FIRE RISK MANAGEMENT, INC

Memo Report

Subject: Independent Fire Protection Review for Cumberland County Civic Center Renovations

A review has been completed of the updated sets of fire protection construction documents (CD), which have been developed to support renovation efforts at the Cumberland County Civic Center in Portland, ME. The documents reviewed included both the fire protection demolition and design drawings (updated 4/12/13), along with the design specifications (updated 4/2/13) for the various fire protection and life safety related systems and the Building Code Report (dated 4/16/13).

4/12/2013 3:26:03 PM C:\Users\jlmahar\Documents\375700 - CCCC Electrical_1\jlmahar.rvt

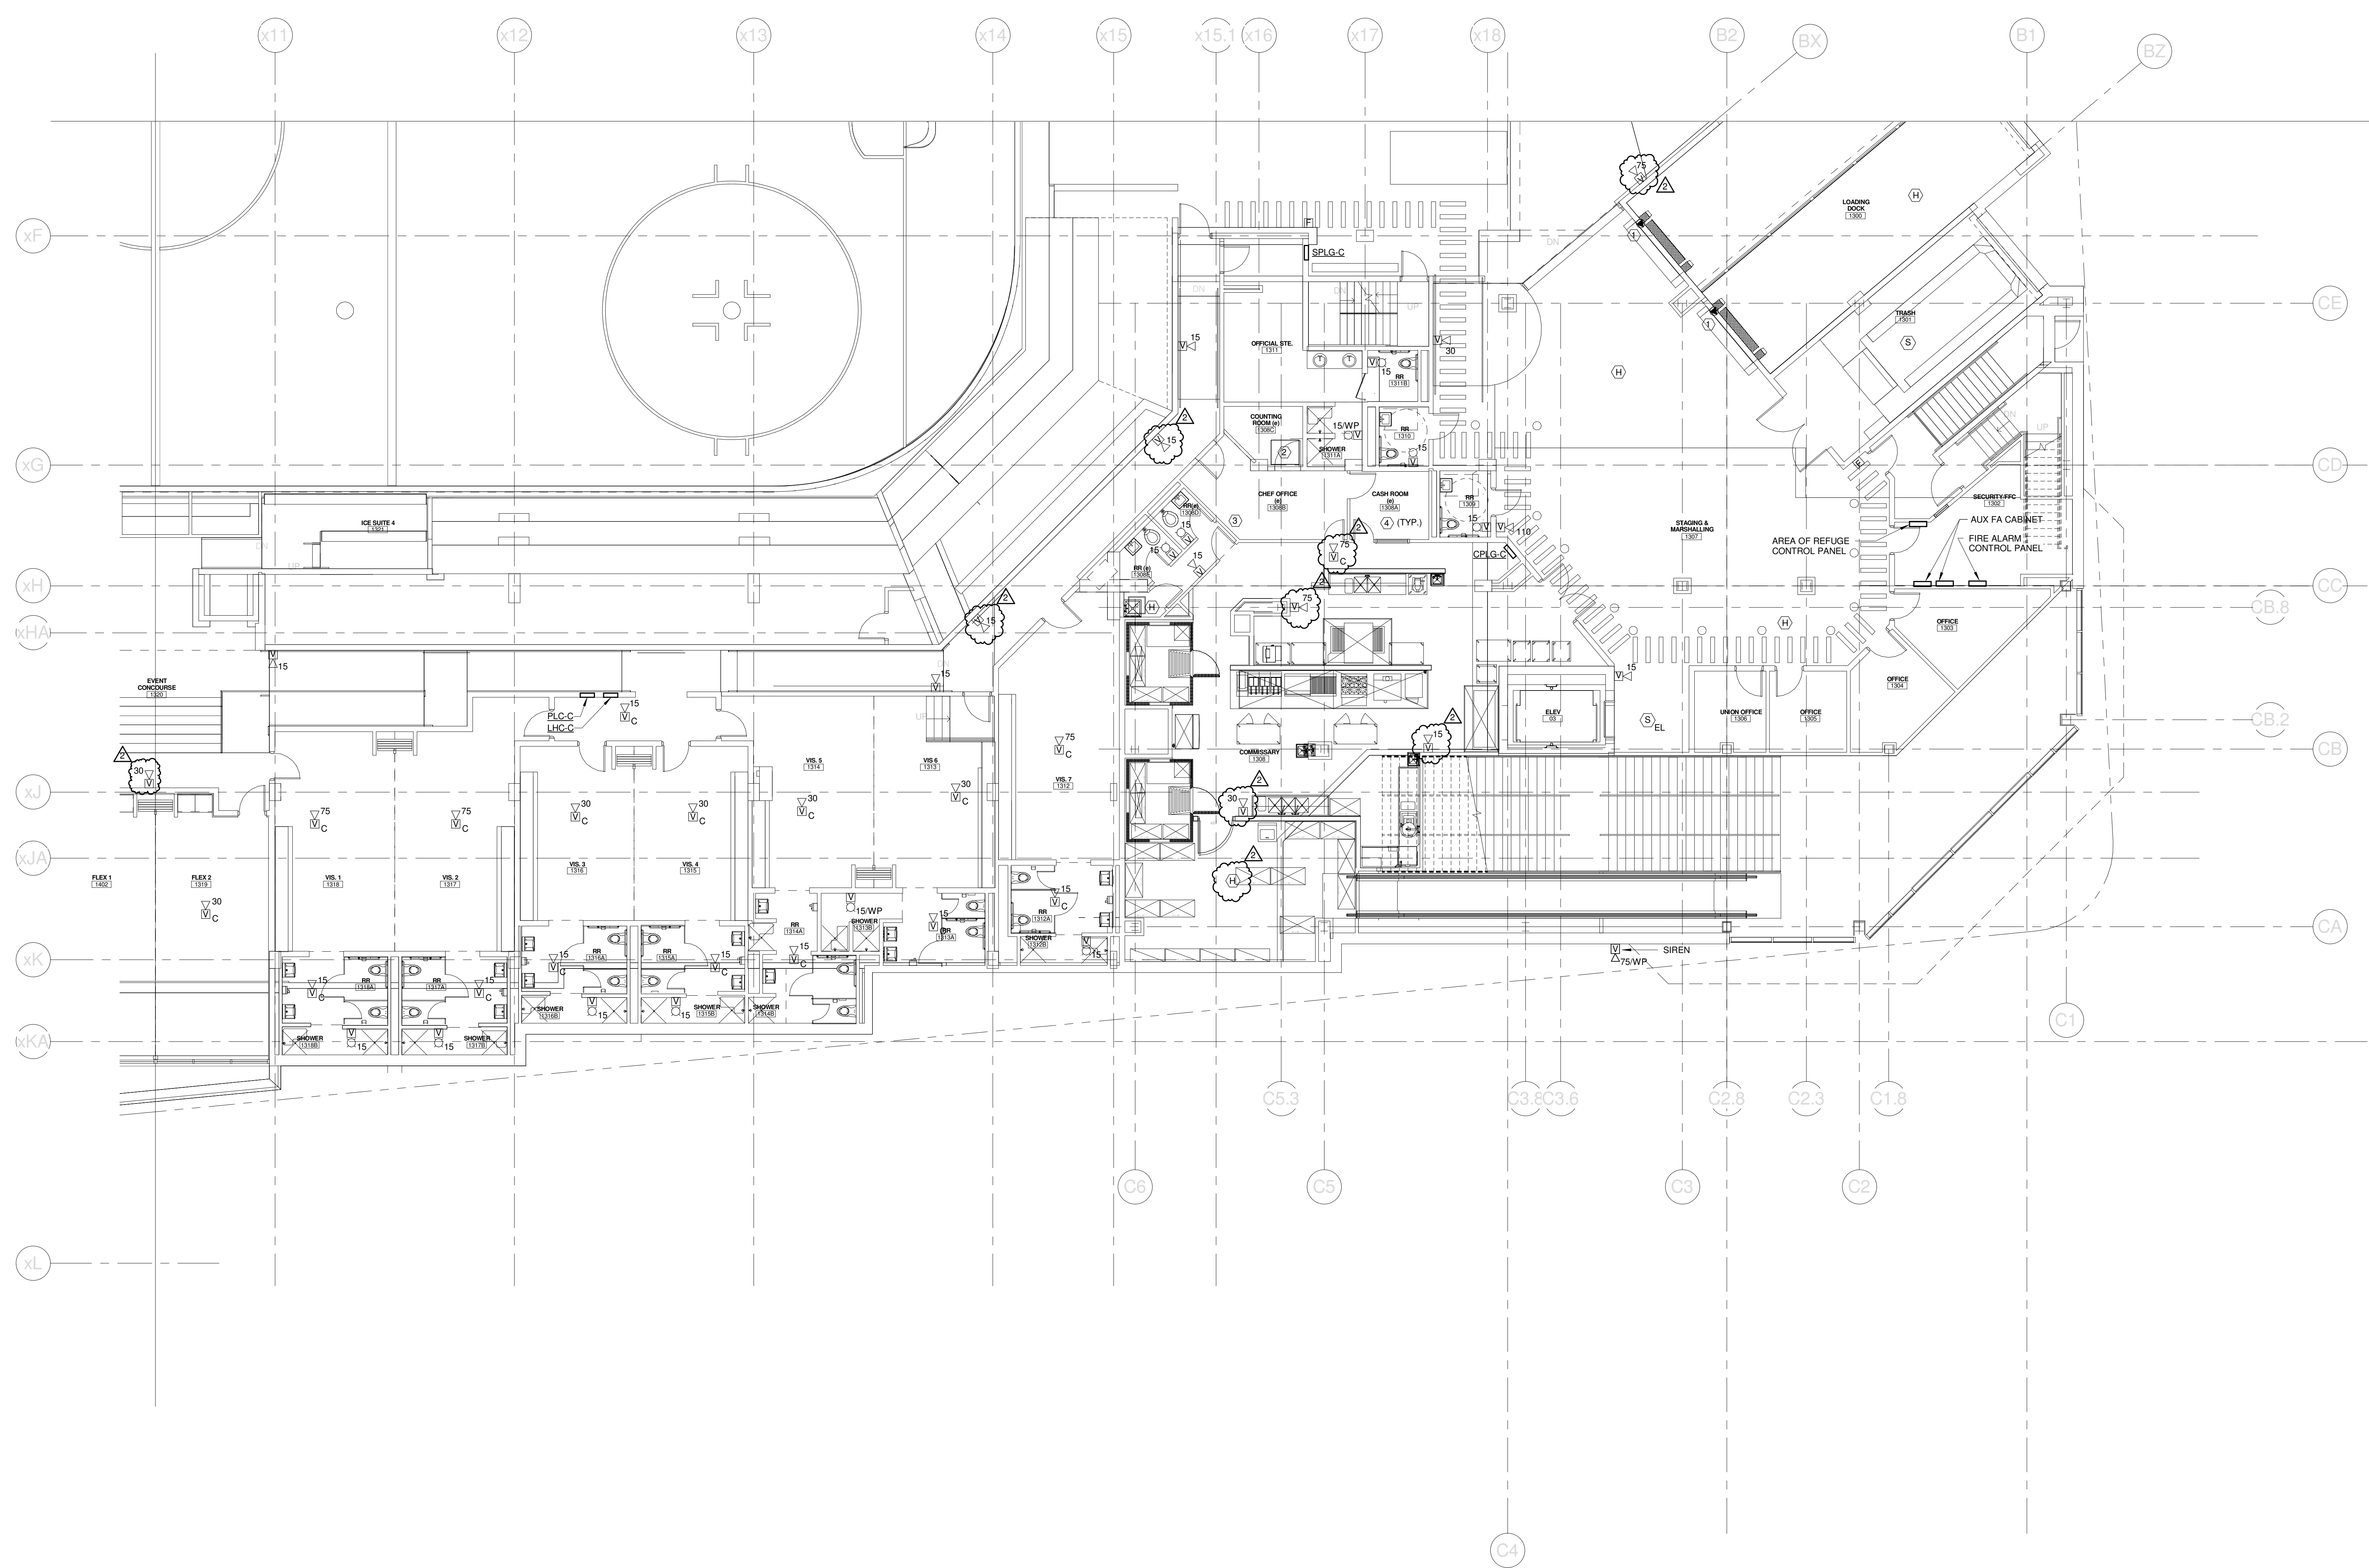
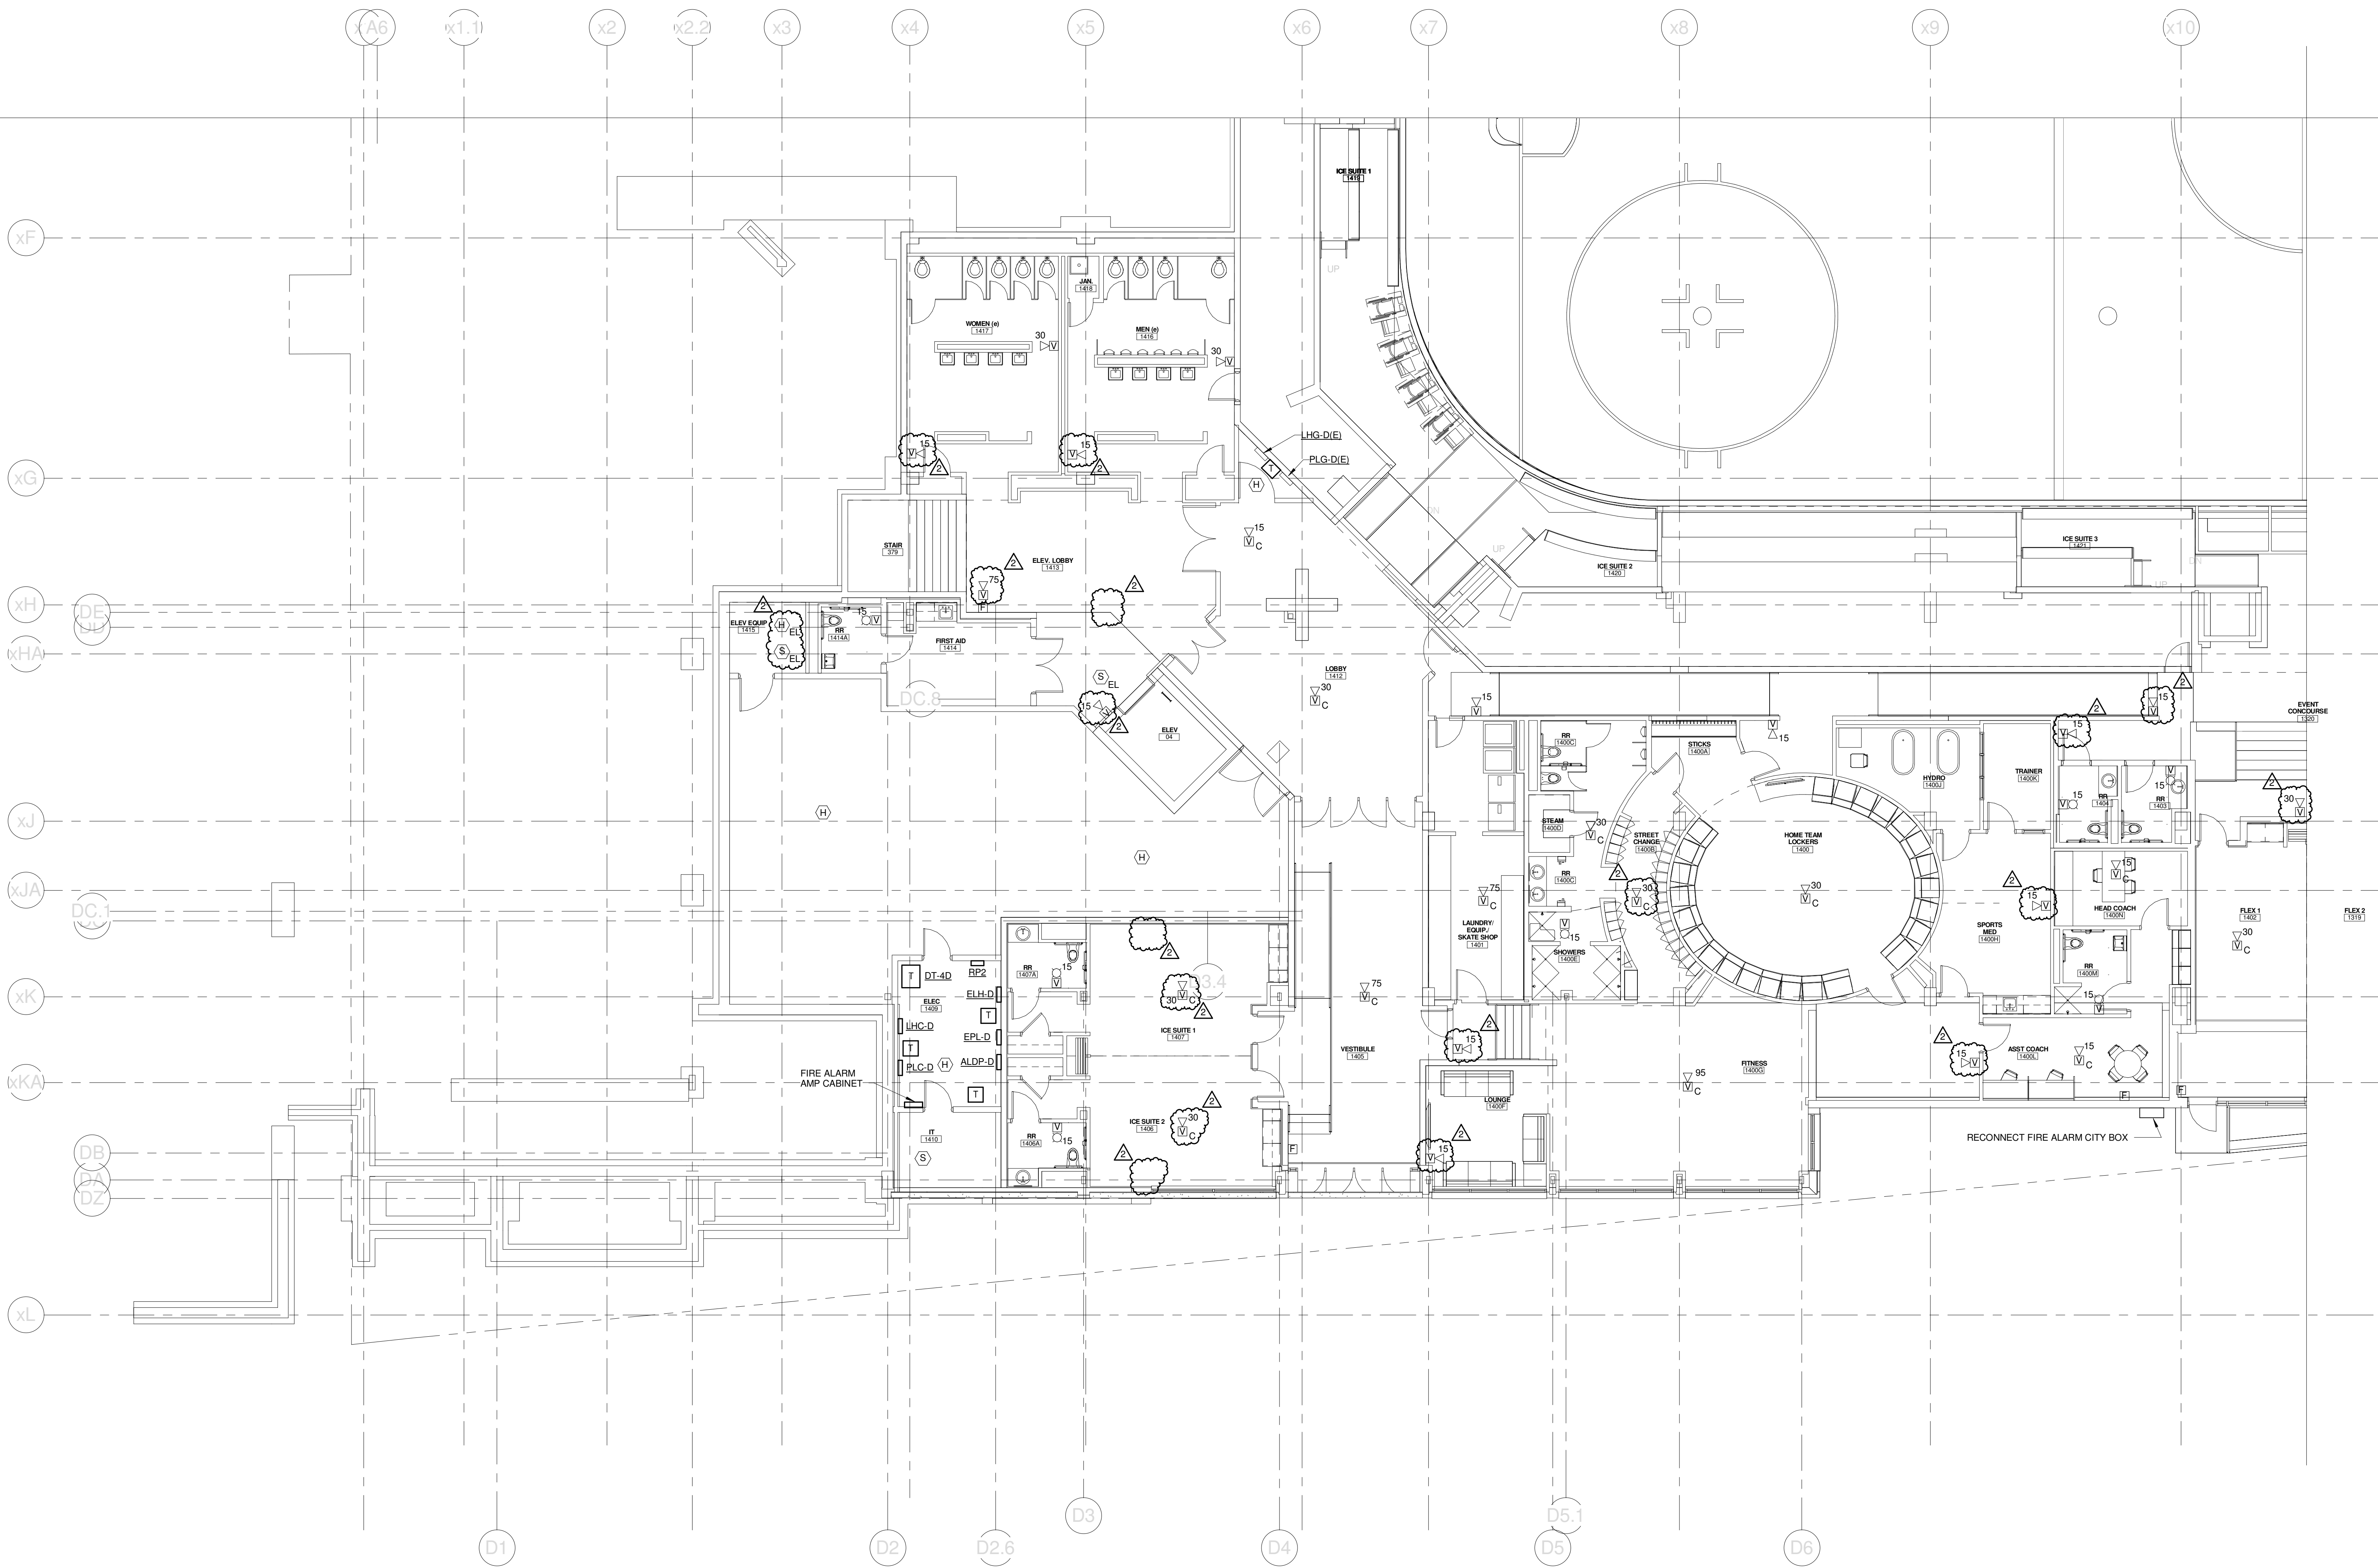
A detailed review of the Fire Alarm system drawings indicates that a number of questions and concerns still exist. Specifically, this includes the many heat detectors that are installed throughout the various spaces within the facility. These devices are unnecessary, given that this facility is fully protected by automatic sprinkler systems, and will represent not only a notable capital cost, but also a significant life cycle cost to the City of Portland. The inclusion of these devices, along with a number of smoke detectors that are not required (such as in corridors of office areas in NW mezzanine), should be verified with the client to ensure they understand and agree with this approach. These devices will provide very little benefit to the overall life safety and fire protection of this facility.

It is recommended that the plans for locating notification devices be reviewed. Specifically, this involves areas that do not require the installation of visual devices, but must still comply with the audibility requirements. Given the locations of the planned notification devices as depicted on the drawings, consideration should be given to the addition of speakers within some of the other non-public spaces that are either relatively large or located such that the sound from the closest speakers may be insufficient to achieve code compliance. It is unknown if any prior sound measurements have been taken to establish “ambient” noise levels throughout the facility, but if not, a contingency plan should be developed to provide an allowance for additional speakers to be provided in areas that may demonstrate insufficient audibility levels during preliminary system testing. Currently, the system specifications do not require the installing contractor to perform such an evaluation prior to the installation of the system to verify device locations.

Based on this recent review, questions regarding the code compliance of the locations of notification devices exist for several areas, including; the Staging and Marshaling and First Aid areas at the west and east ends, respectively, of the Event Level, along with the general plan for notification within the Seating Bowl area. The specific floor to ceiling height within the Bowl area is not specifically depicted on the drawings, but it is believed that this exceeds the 30-foot maximum that is outlined in NFPA 72 for ceiling mounted devices. The only notification devices for the Bowl area are shown on the “Catwalk Level” plan. It is believed that the current plan for notification in the Bowl area would not be considered code compliant; especially as it pertains to the numbers and locations of devices that are installed to support this area.

Although notes exist on drawings identifying the beam type smoke detectors, these devices should also be identified within the legend for the drawings.
